Scoping Opinion - Gortyrähilly Wind Farm, Ballingear, Co. Cork

Ecology Office Advices - Pre-Planning / General Scoping

PPW: 6225 Gortyrhilly Wind Farm, Co. Cork and PPW: 6226 Inchamore Wind Farm, Co. Cork

From: James Dwyer <James.Dwyer@CorkCoCo.ie>
Sent: Monday 4 July 2022 13:13
To: Sean Molloy <smolloy@jodireland.com>
Subject: RE: 6225 Gortyrahilly Wind Farm Ballyvourney Co. Cork - Grid Connection & Turbine Delivery Route Drawings

Legend

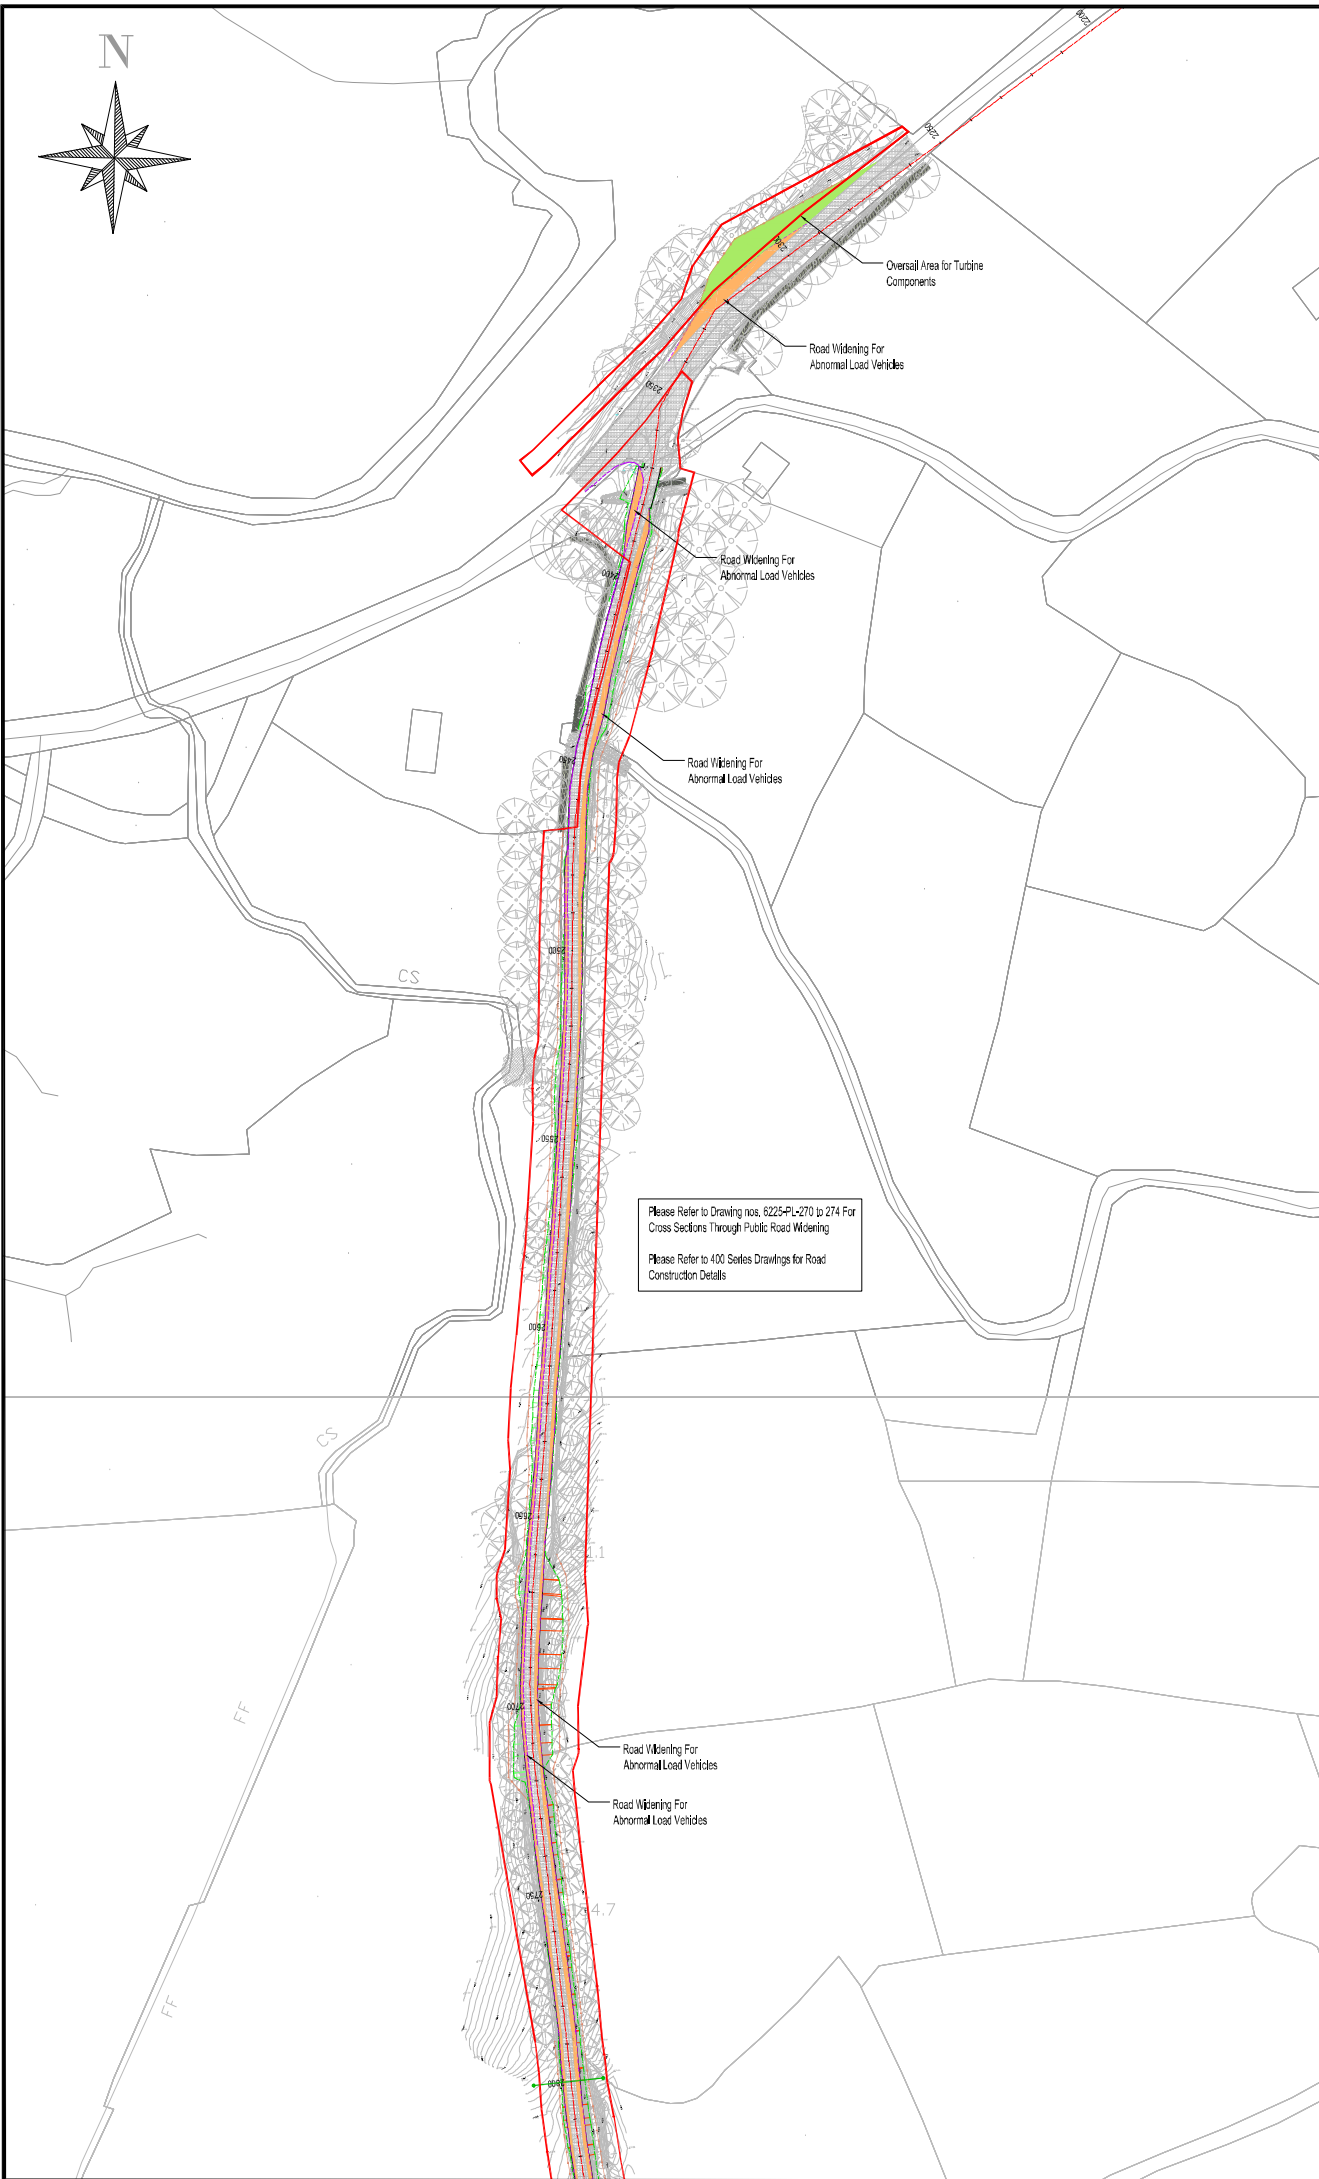
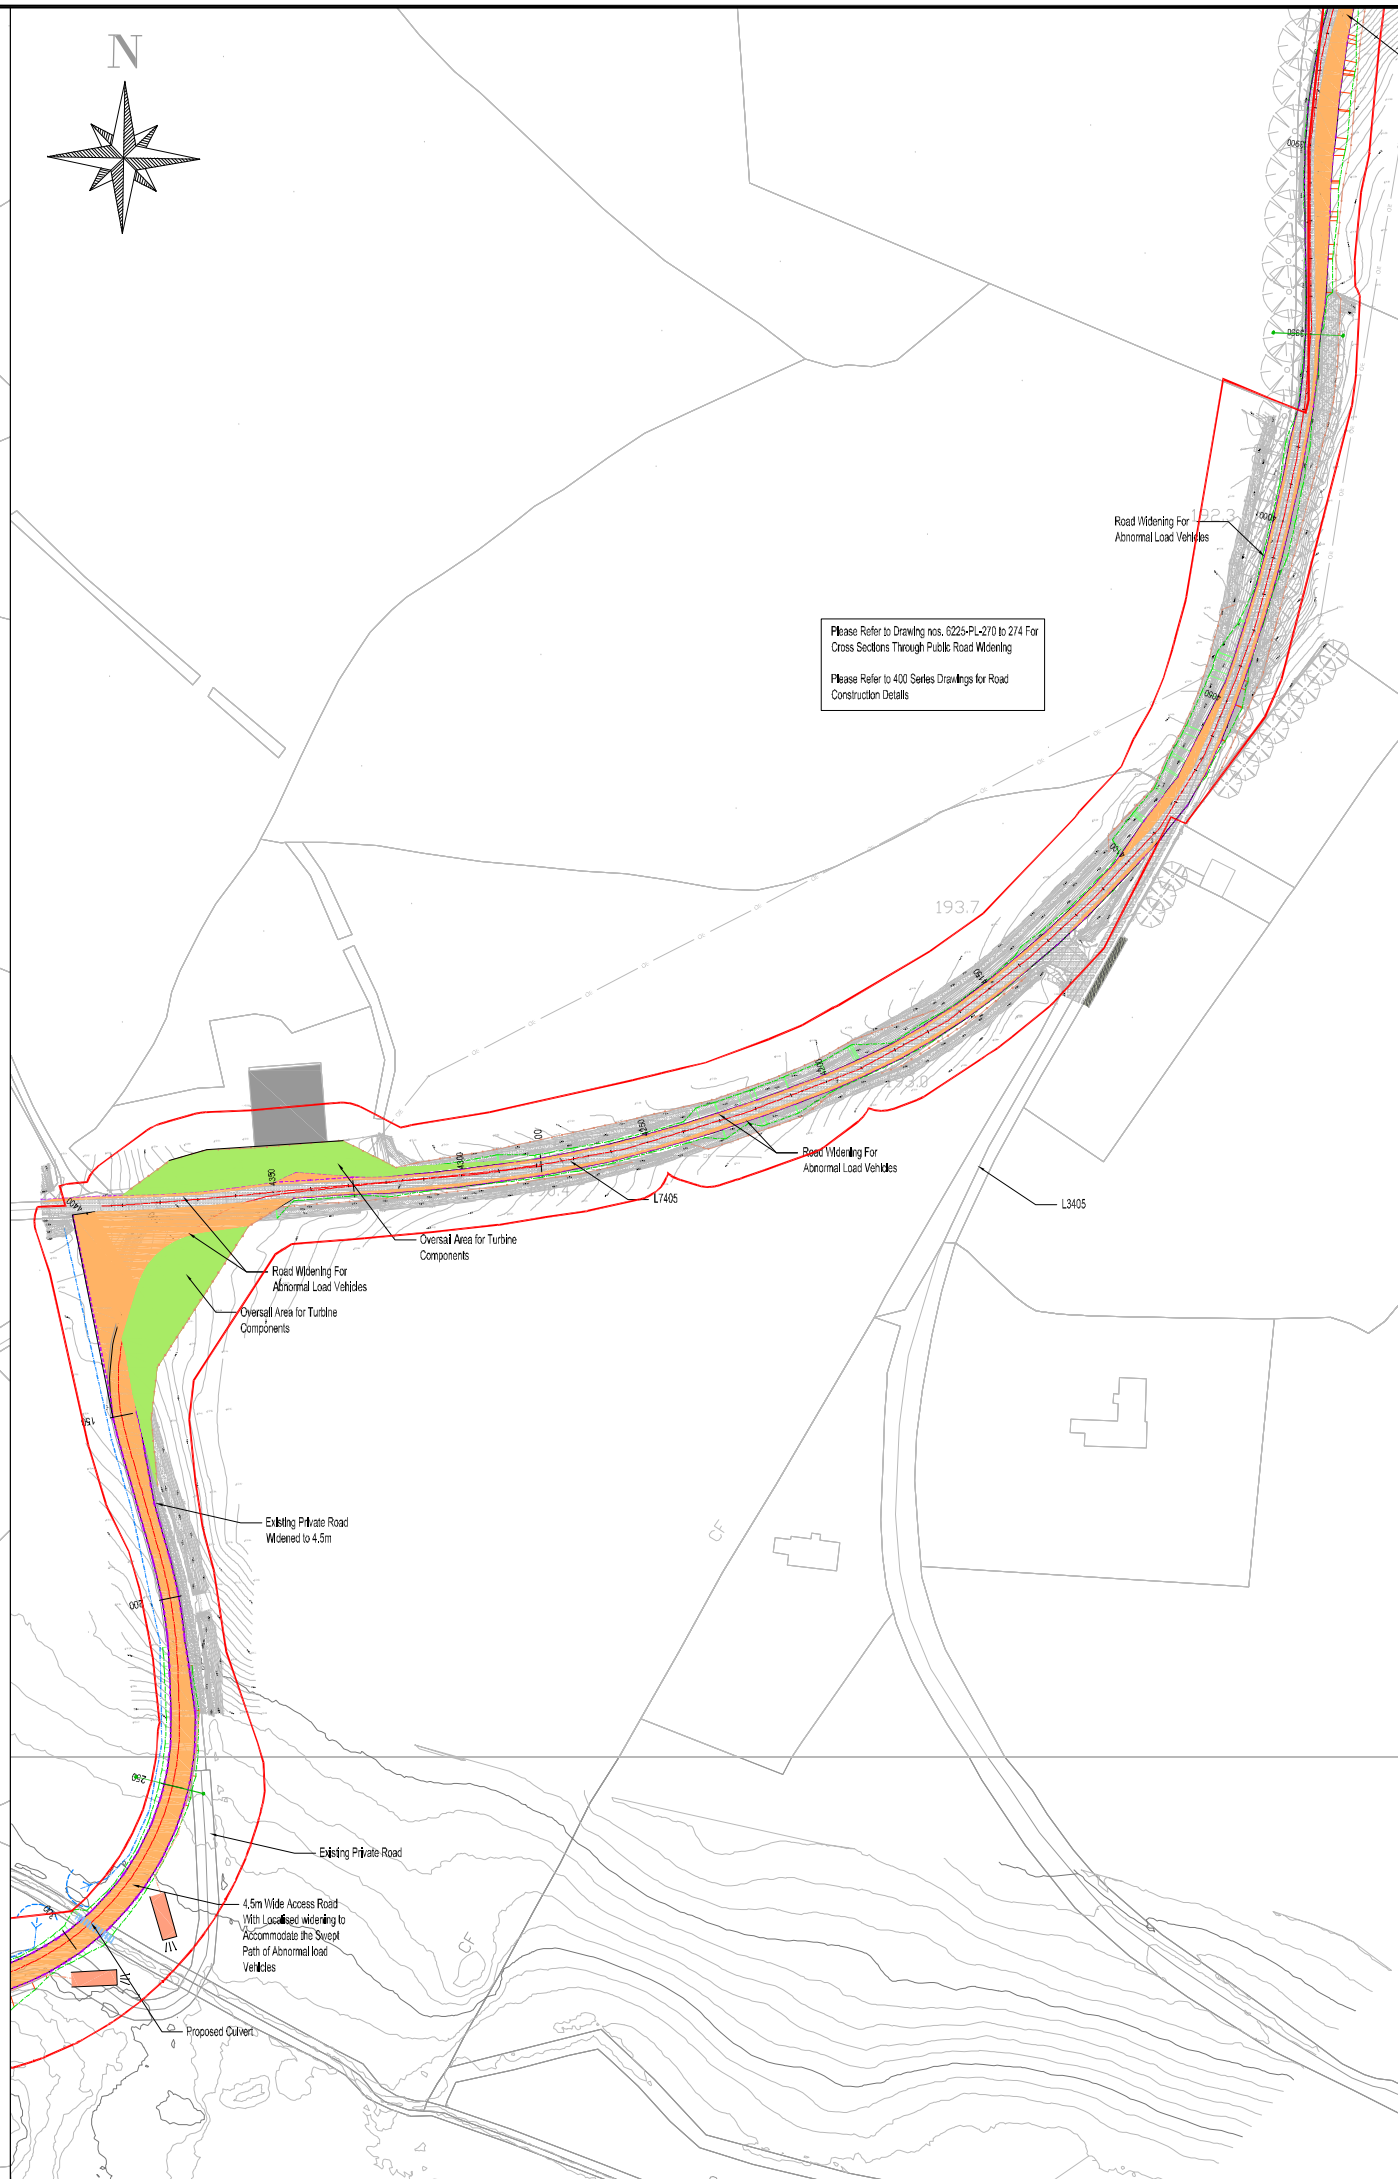
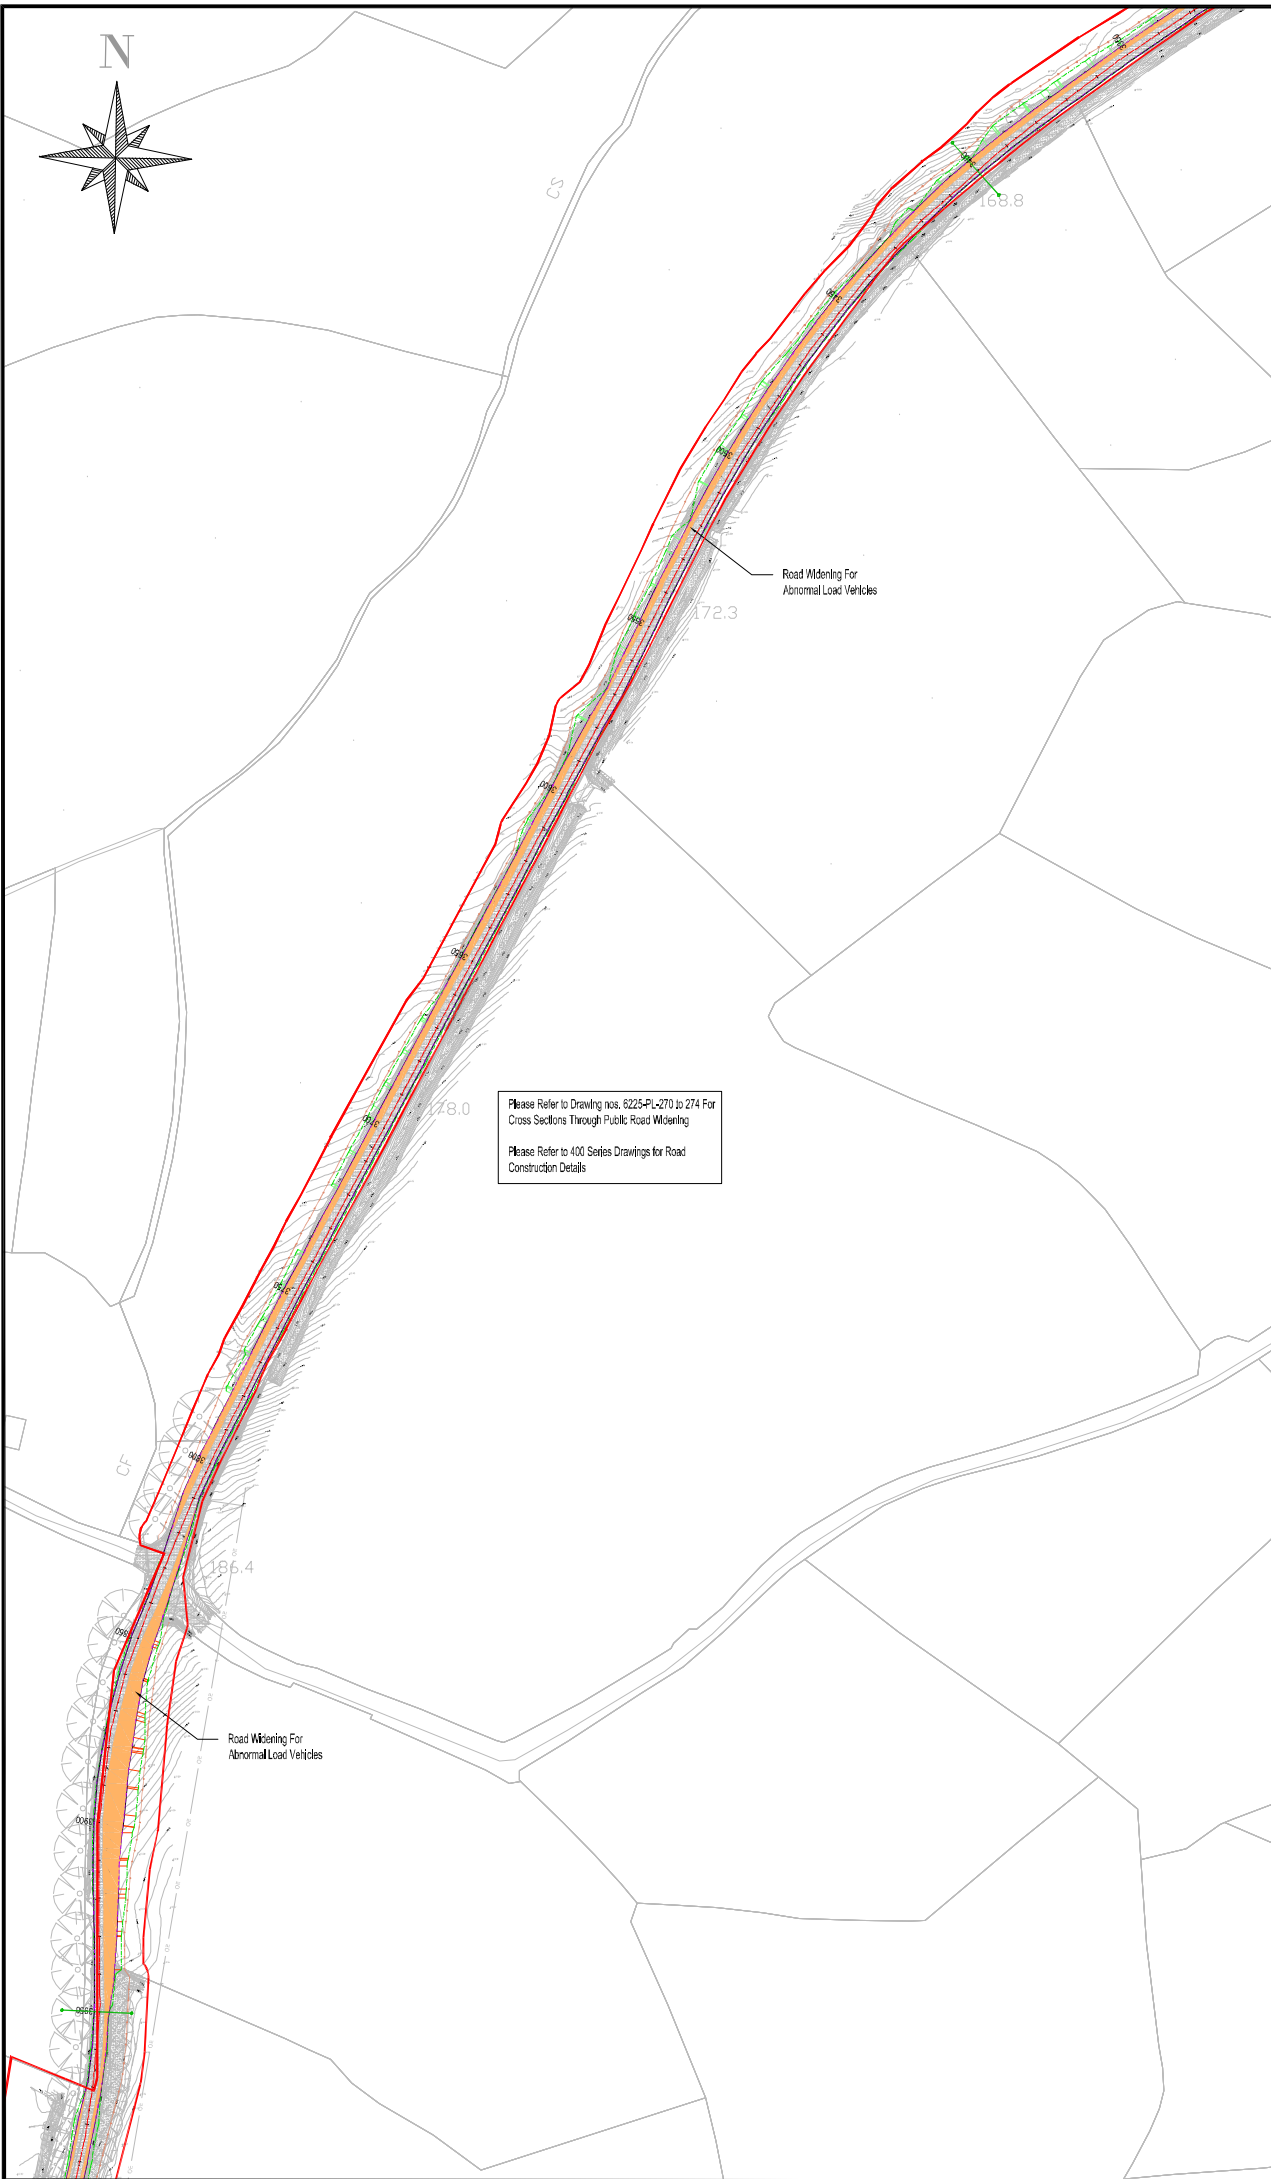
My comments on the delivery route are as follows:

- My previous comment re the junction off the N22.
- The consents for the re-installation of the temporary bridge could be difficult.
- Widening and strengthening of the local road network from the main Coolea/Ballyvourney road south will be required.
